Rezoning Transportation Analysis

Petition Number: 2021-176

Date	Description
11-19-21	First Review (TM)

CONCEPTUAL REZONING PLAN SCALE: 1" = 20'

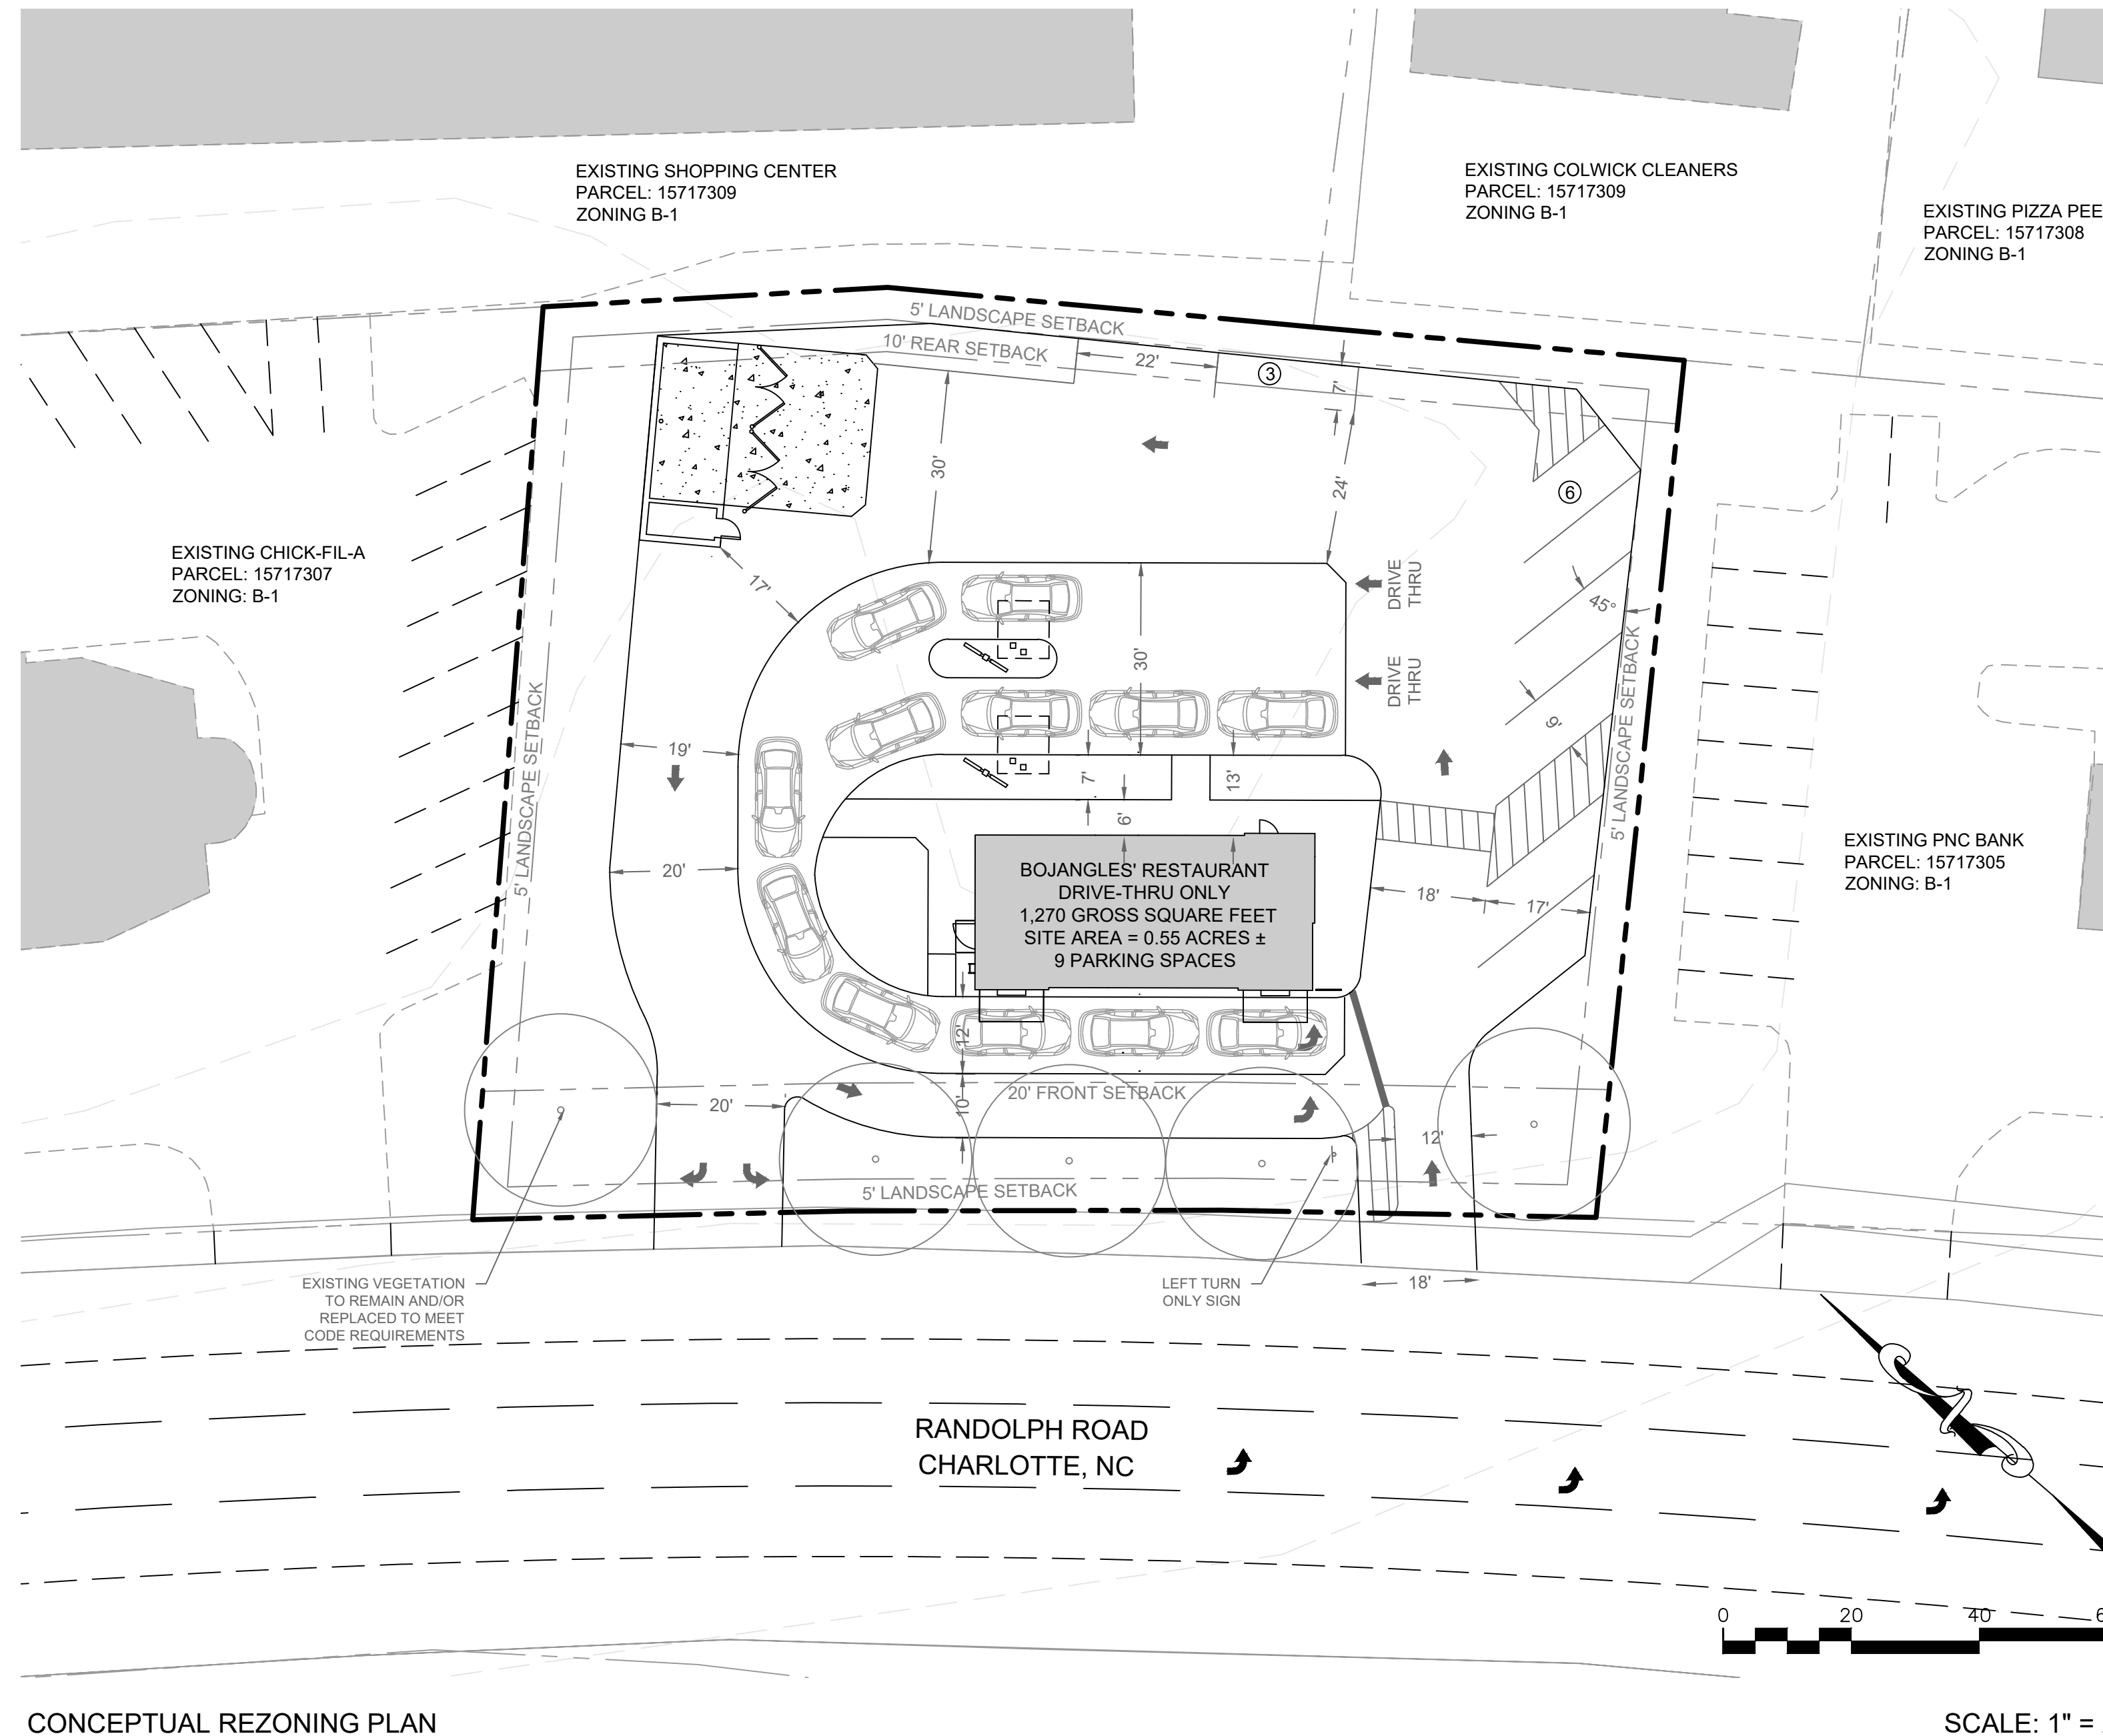
1. **Curbline:** The proposed zoning district has a setback measured from back of the existing or proposed future curbline.
 - a. **Randolph Road:** The future location of curb and gutter will be 41-feet measured from the existing centerline to the back-of-curb. Label and dimension the existing and future back-of-curb from the existing centerline.

3. Revise site plan and conditional note(s) to commit to dedicate 50 feet of right-of-way from the Randolph Road centerline. The site plan shall label and dimension the right-of-way from the road centerline.
4. Revise site plan and conditional note(s) to commit to construct an 8-foot planting strip, and 6-foot sidewalk on Randolph per Chapter 19. The site plan shall label and dimension both items from the back of curb and gutter and road centerline.
5. Revise site plan and condition note(s) to commit to removing the sidewalk transition to the south of the site along Randolph Road and continuing the 8-foot planting strip and 6-foot sidewalk to tie-in to the property's sidewalk.

6. Revise site plan to provide type II modified driveways along Randolph Road per CLDSM 10.25E.
7. A site plan note(s) specifying dedication and fee simple conveyance of all rights-of-way to the City before the site's first building certificate of occupancy is issued as needed. CDOT requests rights-of-way set at 2' behind back of sidewalk where feasible.
